**Re: Objection to MP08\_0244 MOD 1 Modification Request for Mixed Used Development at 23-37 Lindfield Avenue and 11 Havilah Lane, Lindfield**

As a resident of Lindfield, I/we wish to lodge an objection against the proposed Modification of the subject development based on the following grounds:

ELEVATIONS

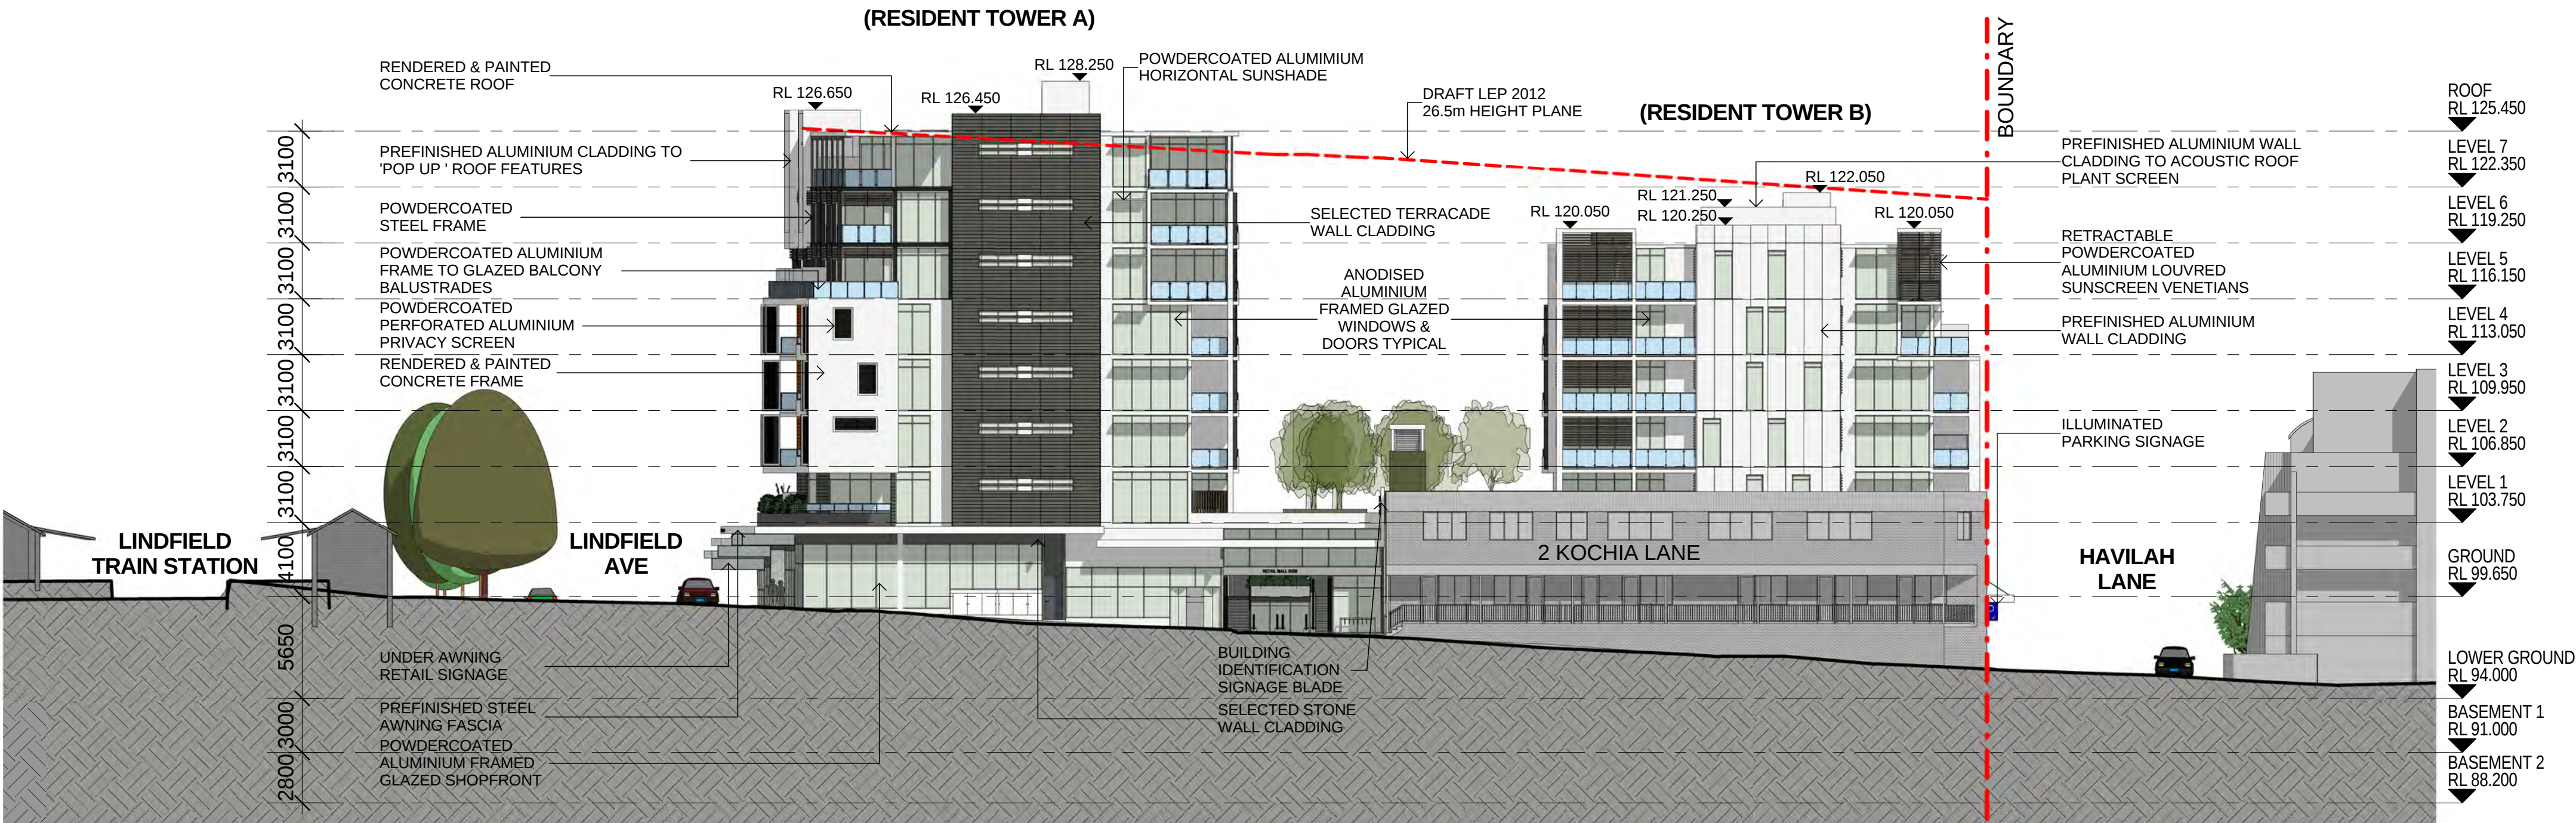
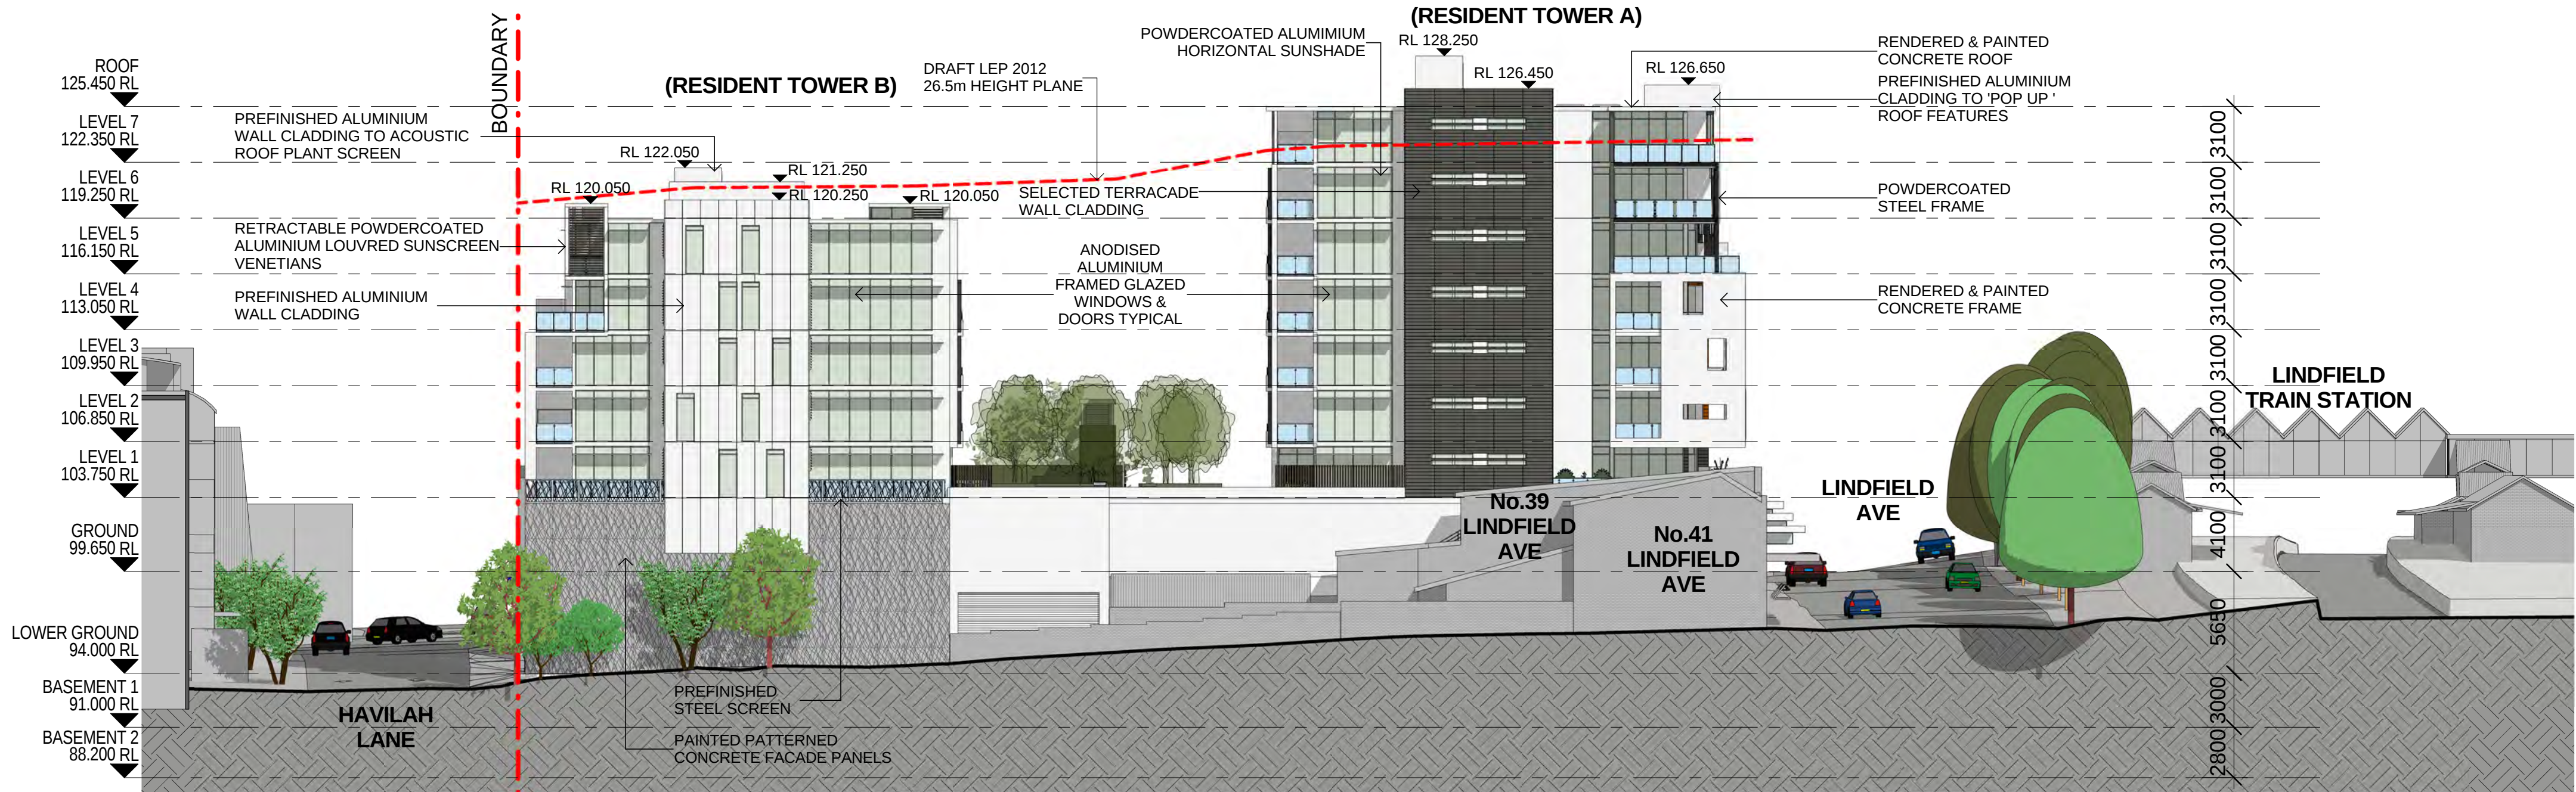
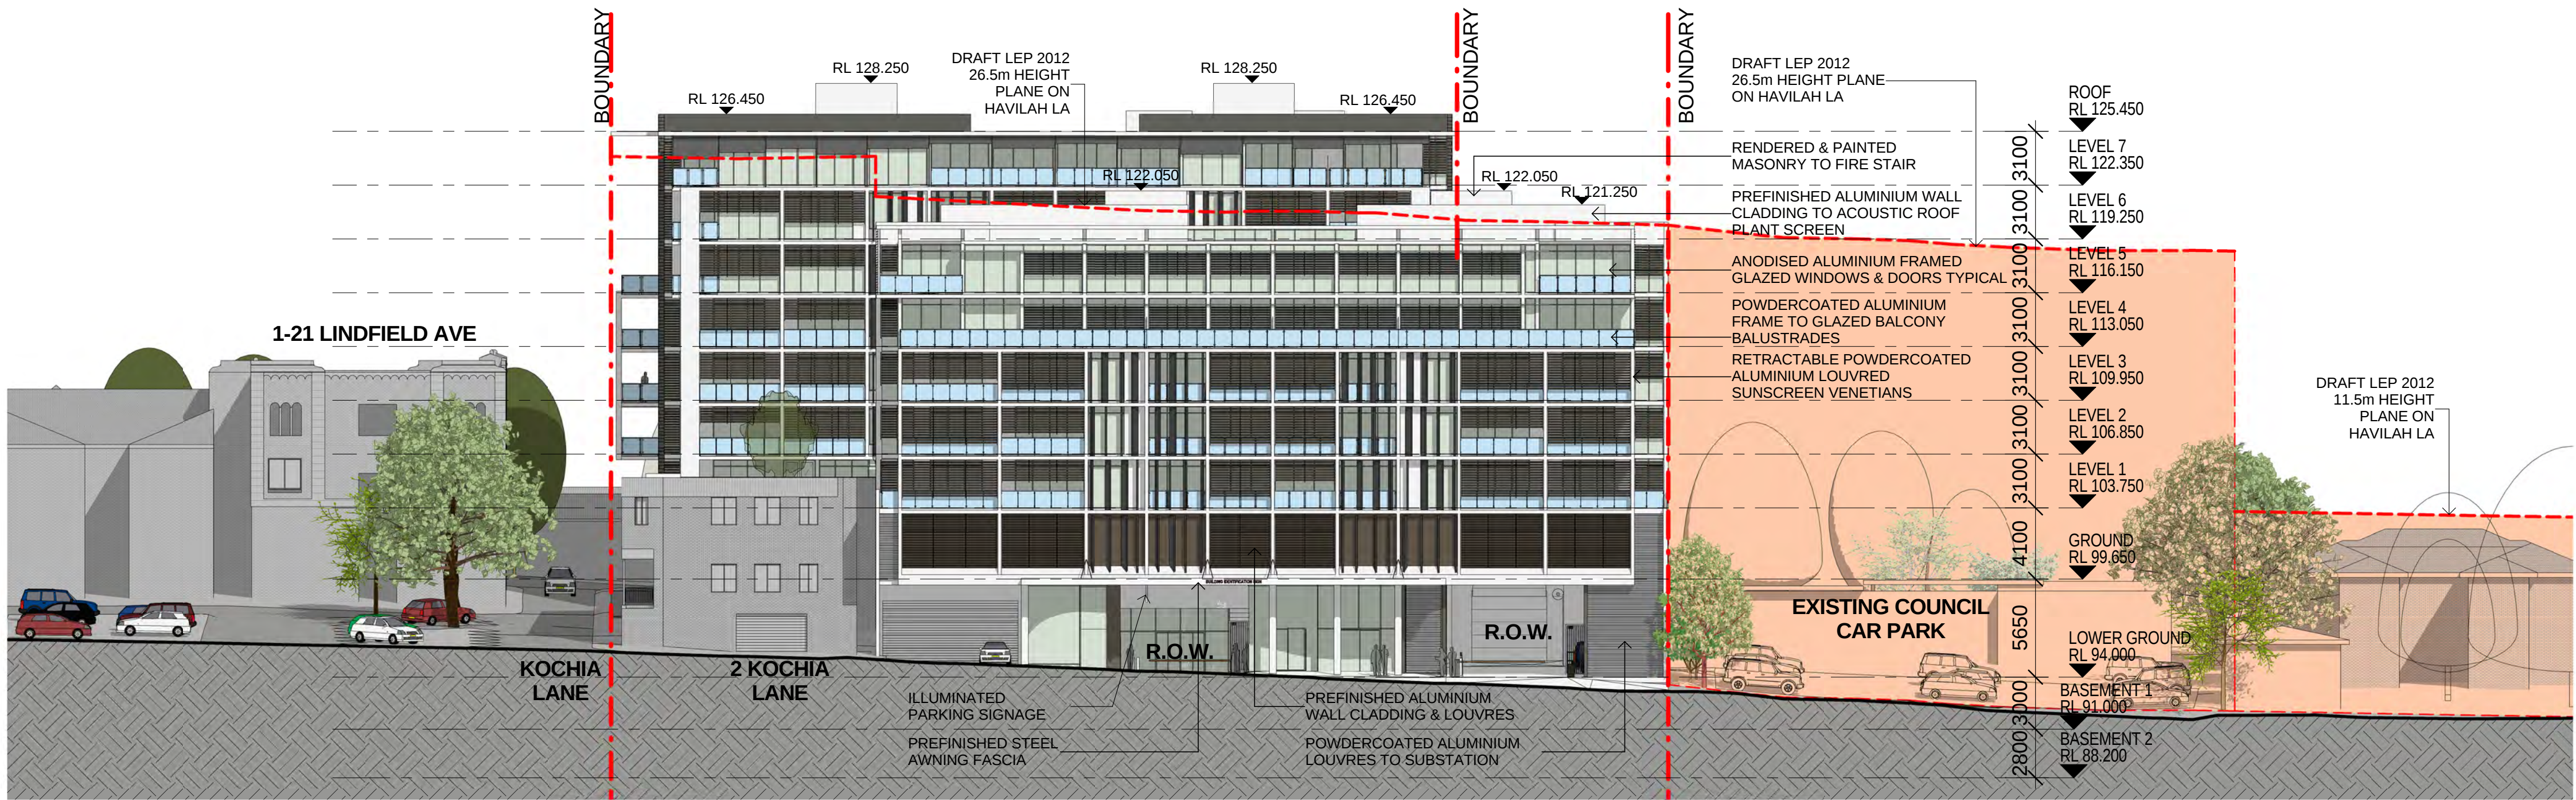
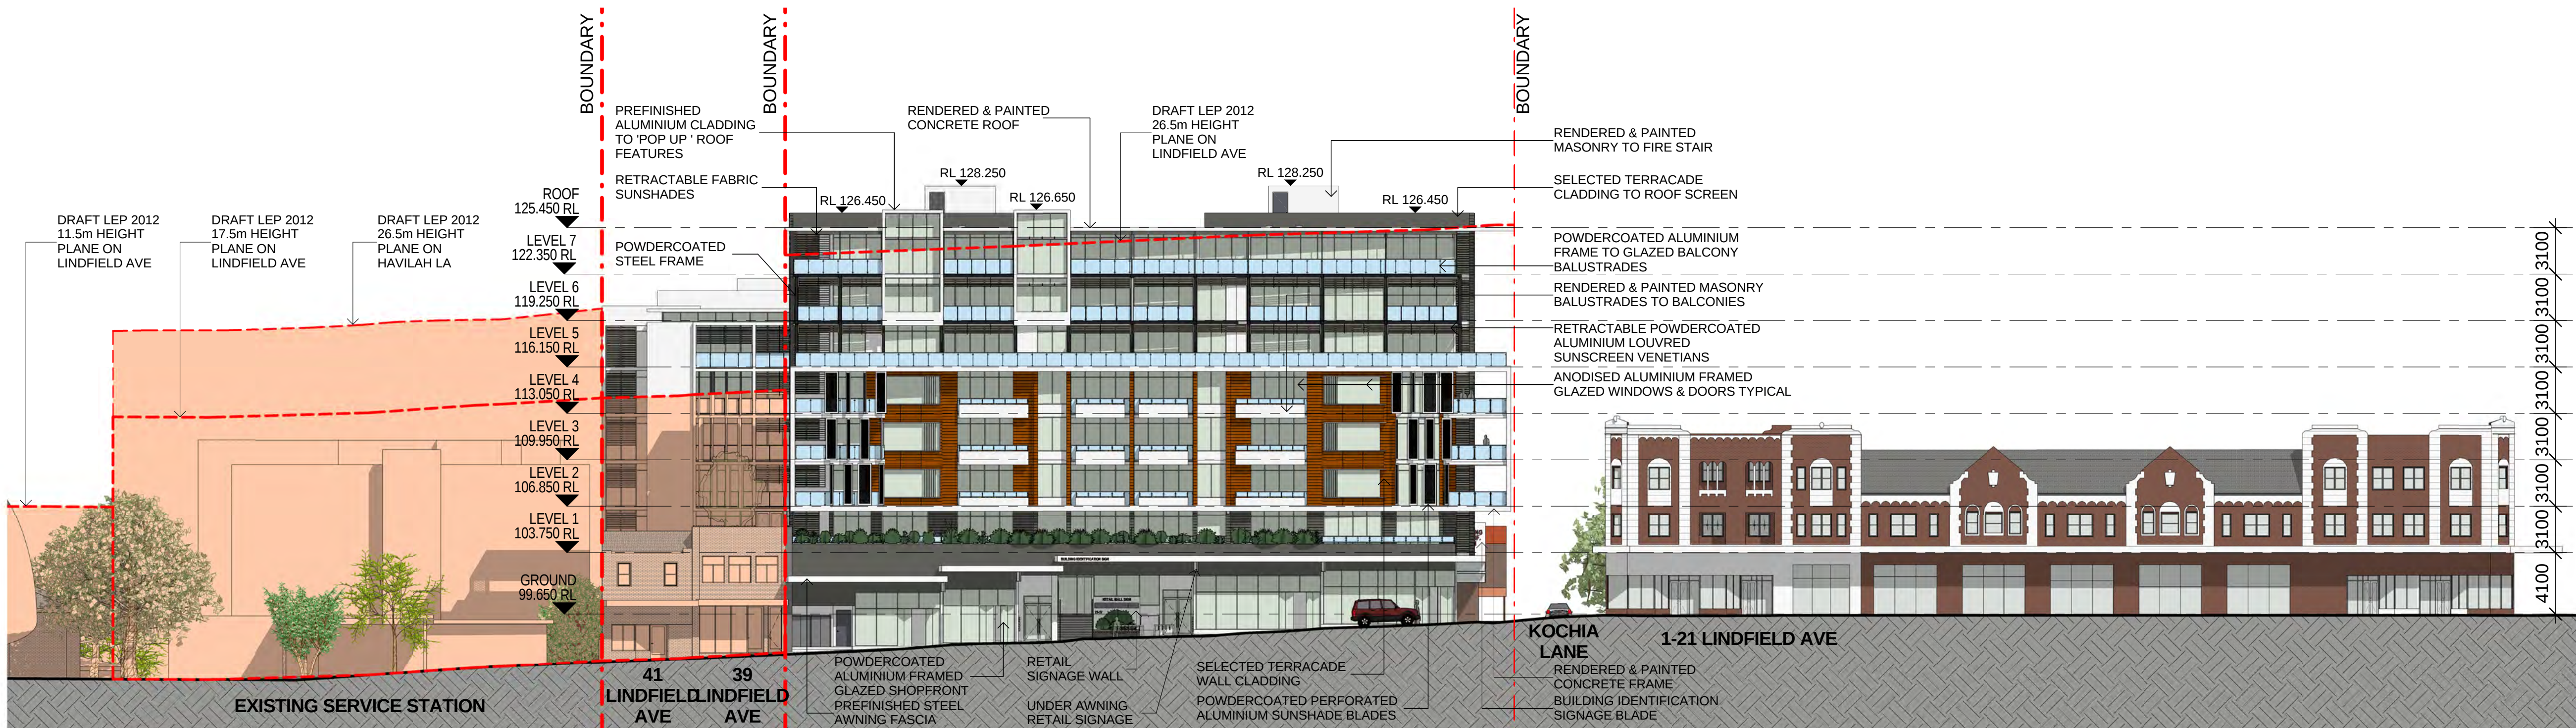
- The increase of an additional storey to both buildings: 8 storeys on Lindfield Avenue and 7 storeys on Havilah Lane creates excessive height and bulk and is out of character with the surrounding buildings, including the heritage listed adjacent building on Lindfield Avenue

- The additional storey (combined with less set back than the approved design) on Havilah Lane now creates privacy concerns for over 40 apartments in the adjacent 8 Havilah Lane, 8 Kochia Lane and 2-8 Milray Street residences
